**From:** ENVU Biodiversity and Land Use  
**Sent:** 29 September 2025 07:57  
**To:** Planning ContactCentre  
**Subject:** 2024/92031 at location Headlands Works, Headlands Road, Liversedge, WF15 7NT

Please see ecological commentary below:

Figure 3 Landscape Proposals dwg. LDP-24-P218-1001 rev. A (Studio 413 Landscape Architecture, May 2024).

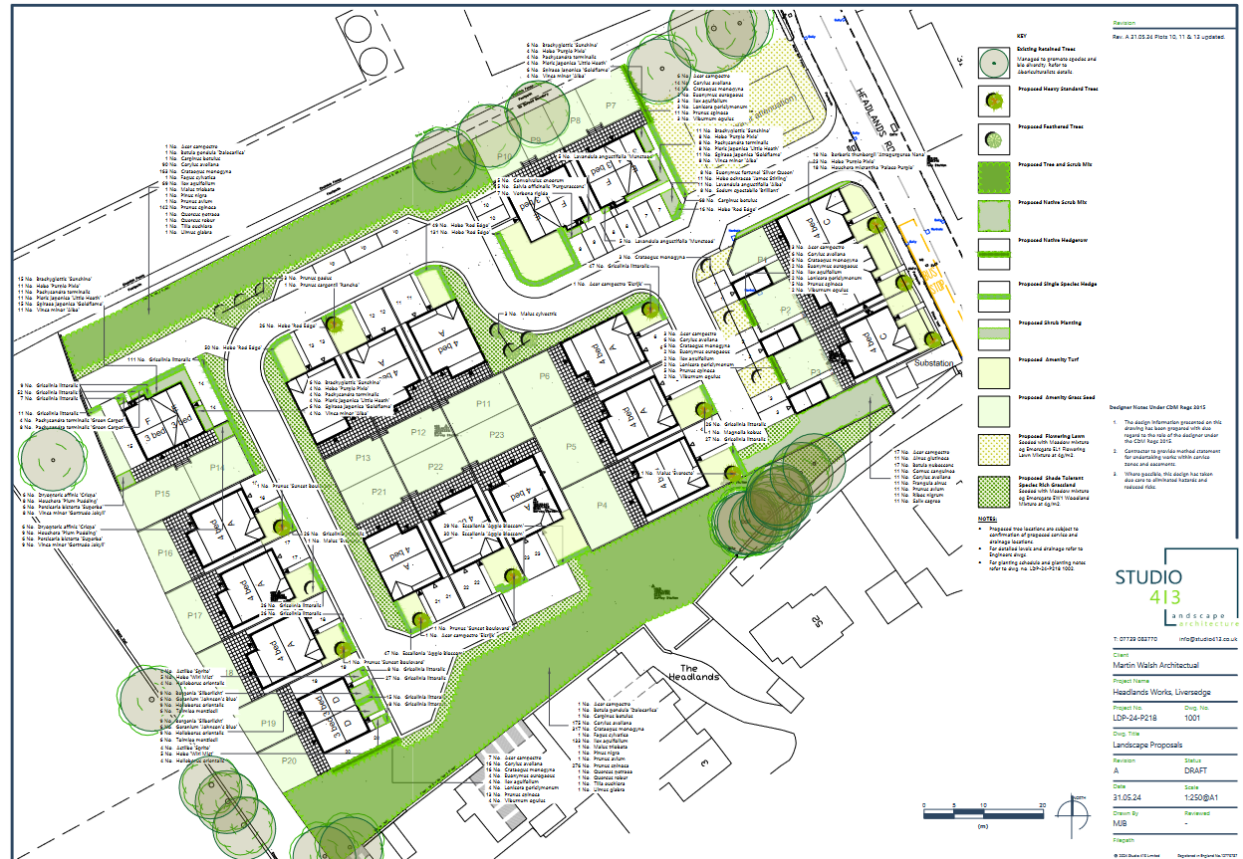
- There are several trees onsite of medium distinctiveness and appear to have suitability of bats (T1, T2, T3, T4, T5, T6, T7, T8, T9) ground level tree bat roost assessments will need to be conducted, and the finding provided in a report prior to determination. There is also no confirmation of trees to be maintained or removed onsite.
